SCOPING OPINION:

Proposed Dudgeon and Sheringham Shoal Offshore Wind Farm Extensions

Case Reference: EN010109

November 2019

Plate 4-23: Construction Programme – SEP or DEP built in isolation

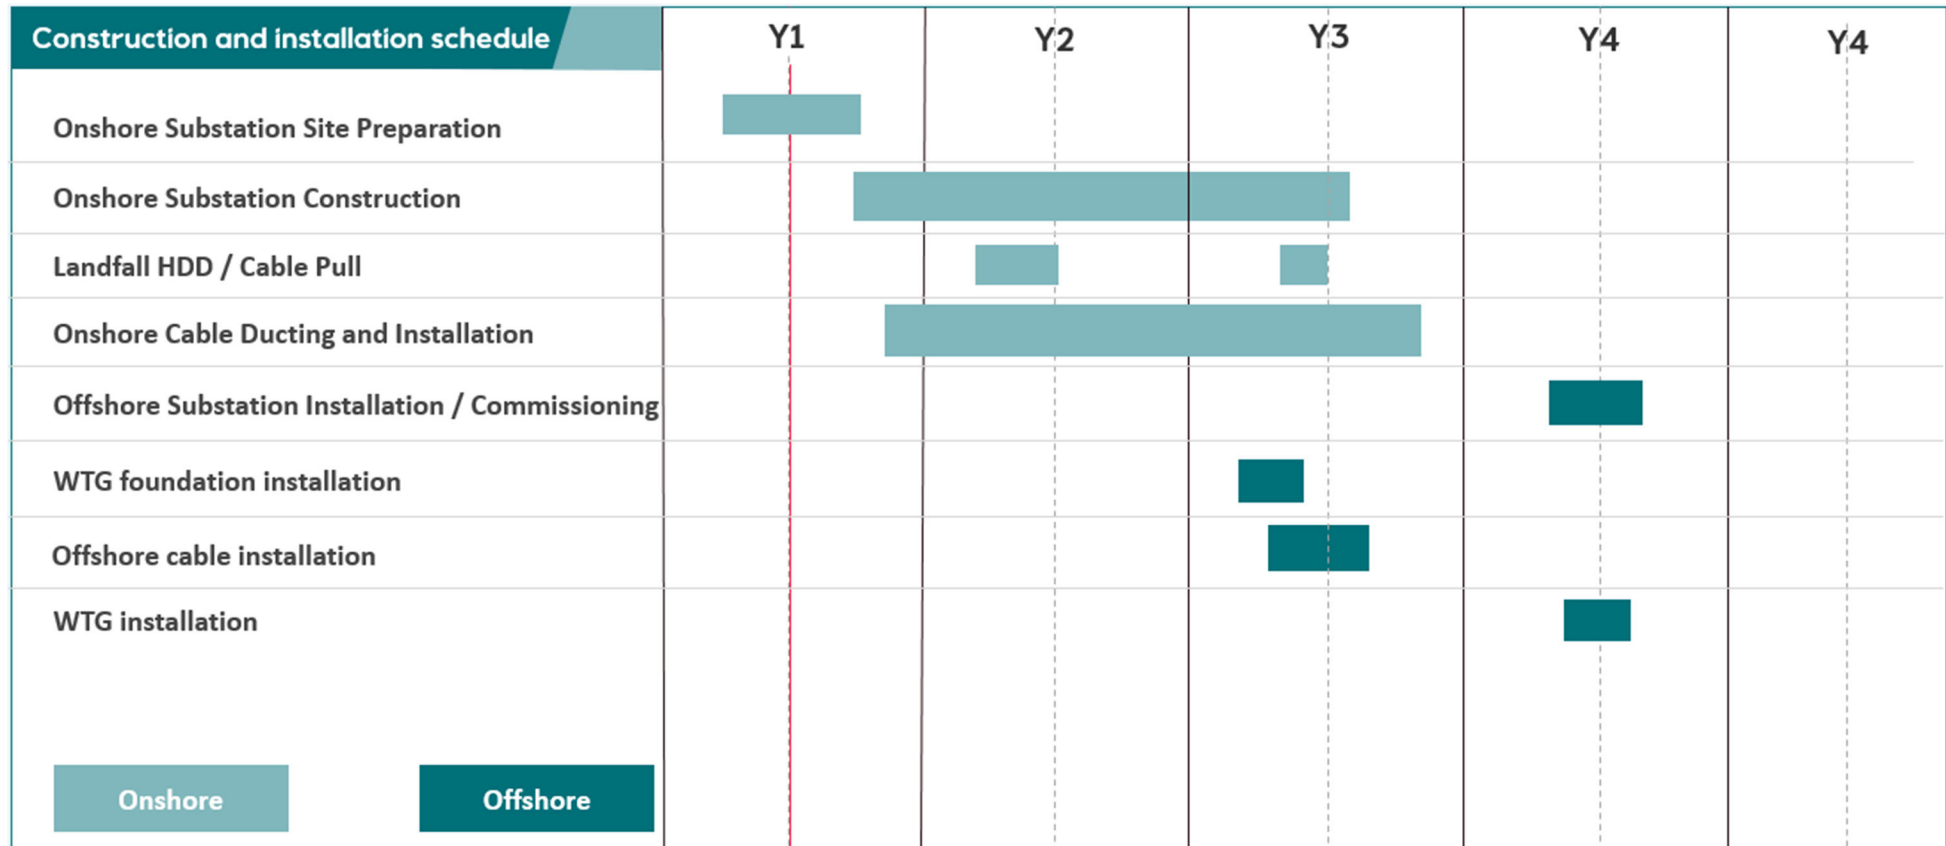
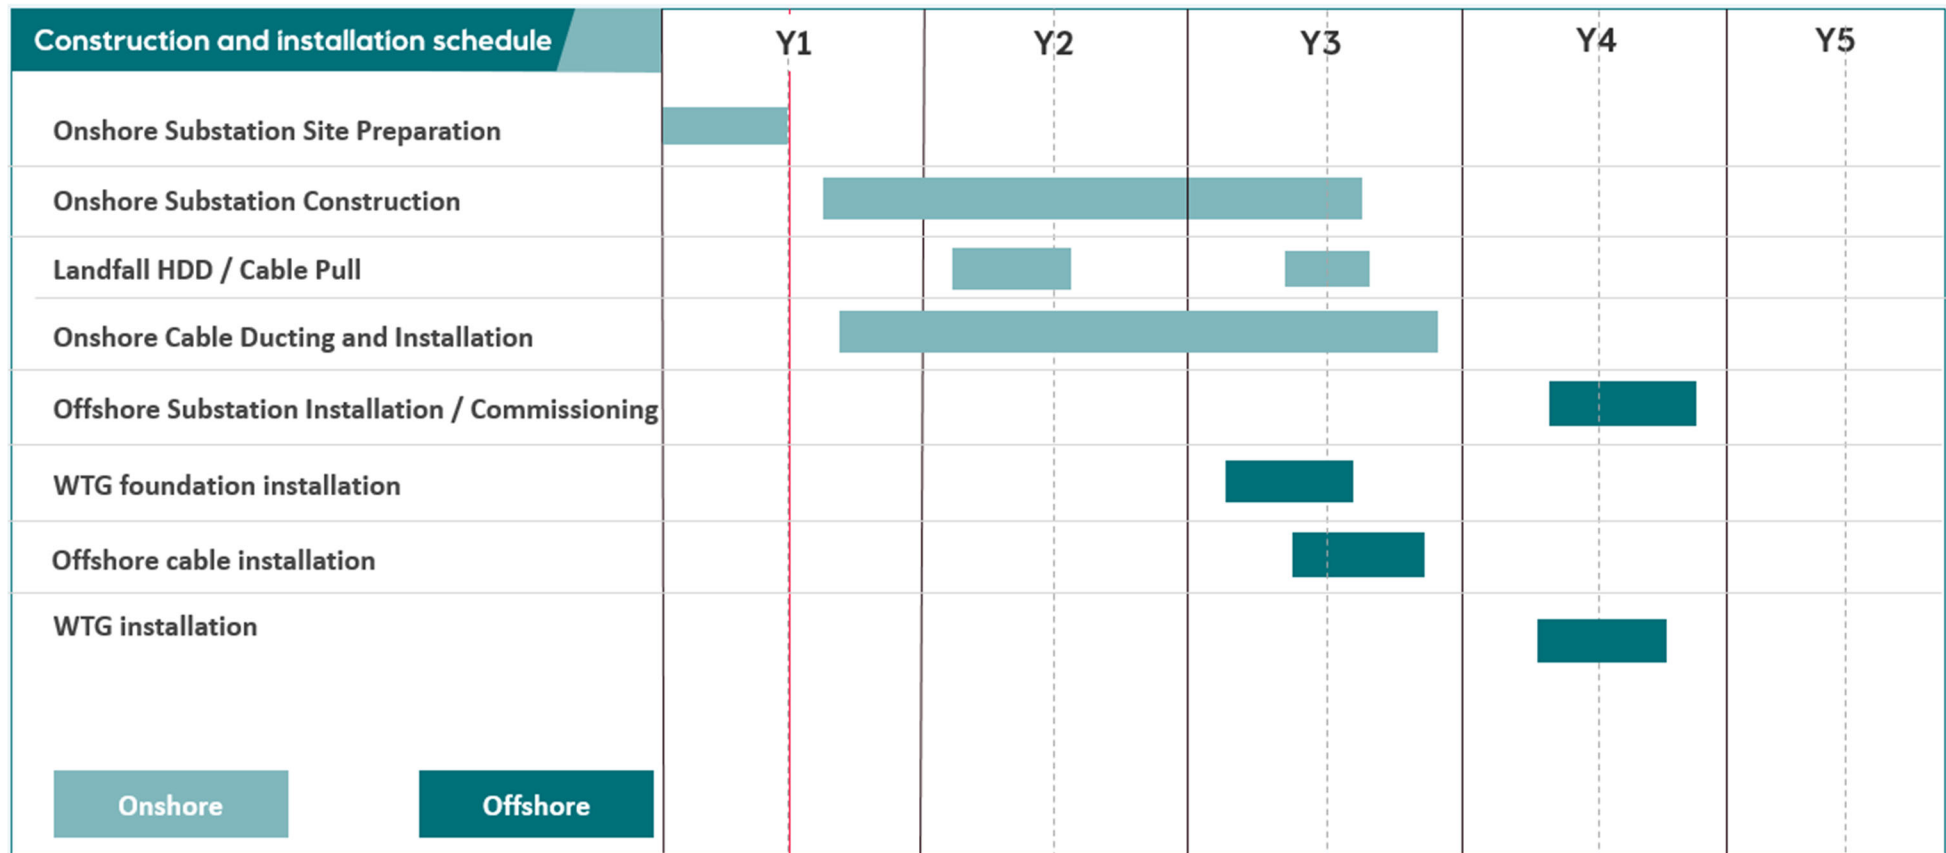
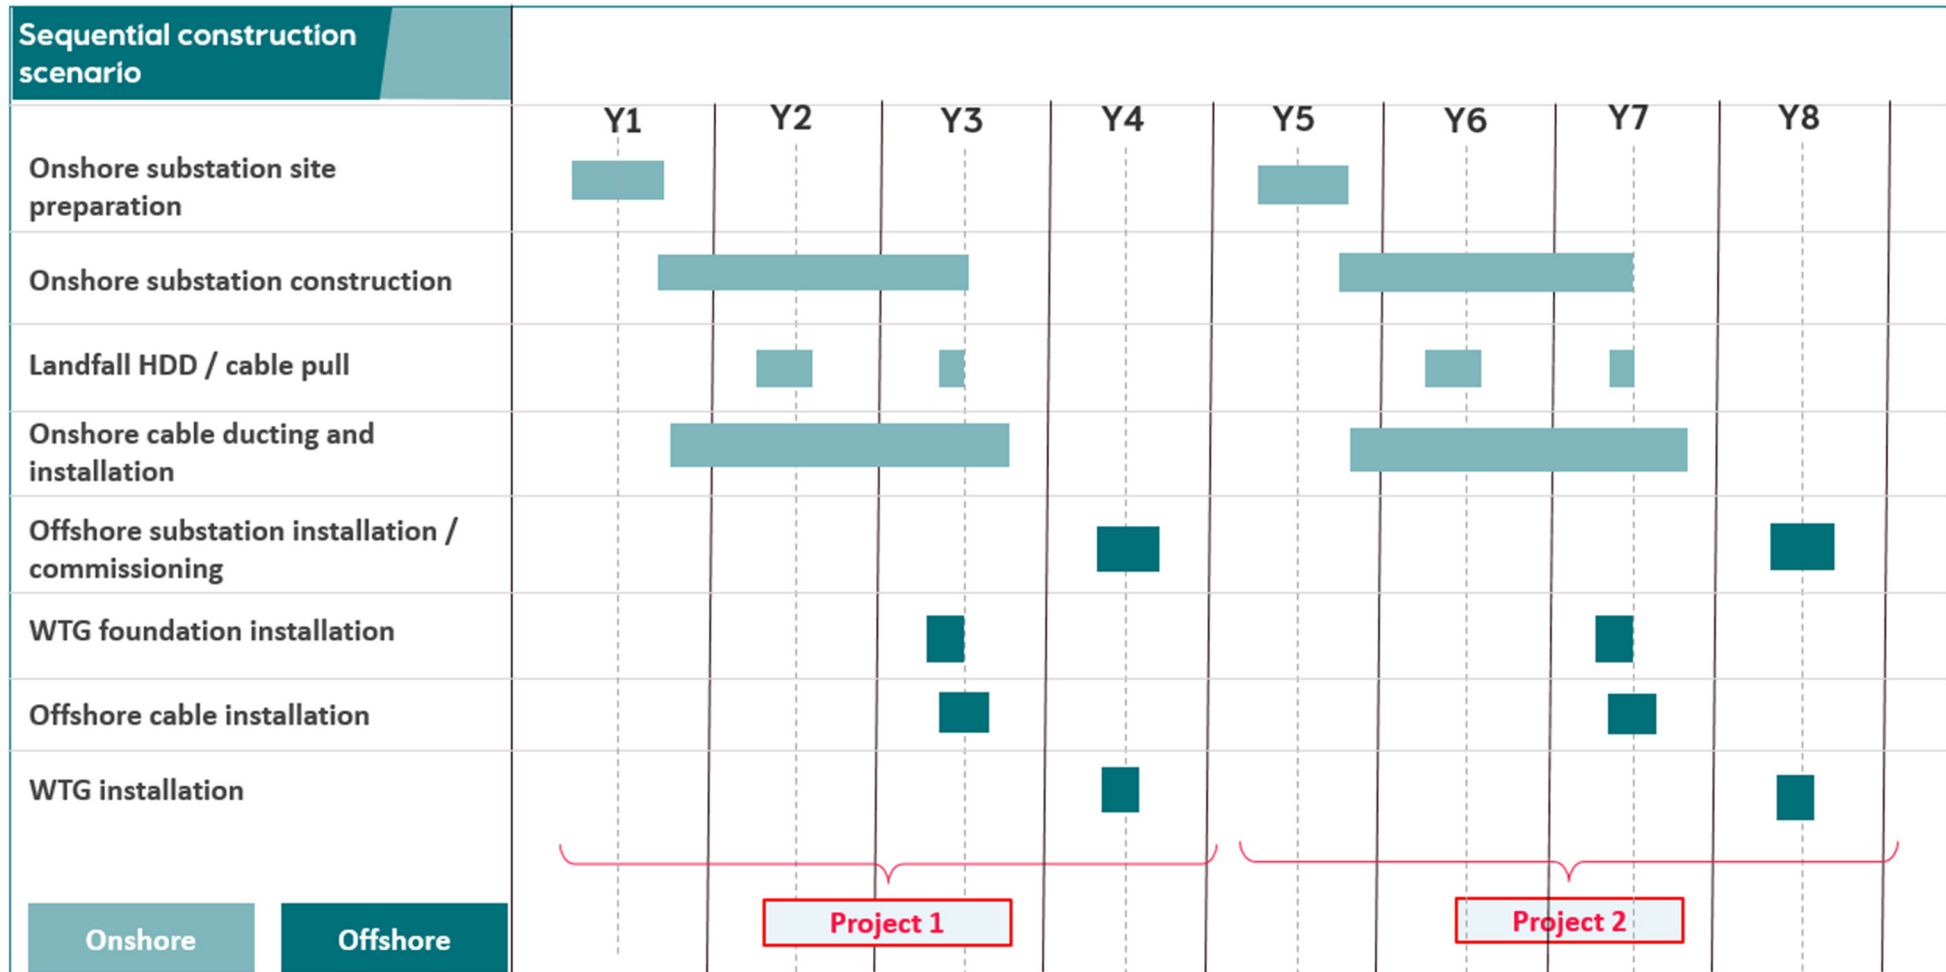
2.3.4 The construction programme for the 'separated' grid option, as depicted on Figure 1.5-6 of the Scoping Report, does not identify the timeframes for installation of the offshore export cable and array cables of Project 2. The Inspectorate assumes this is an error and advises this is corrected in any similar figures to be included in the ES.
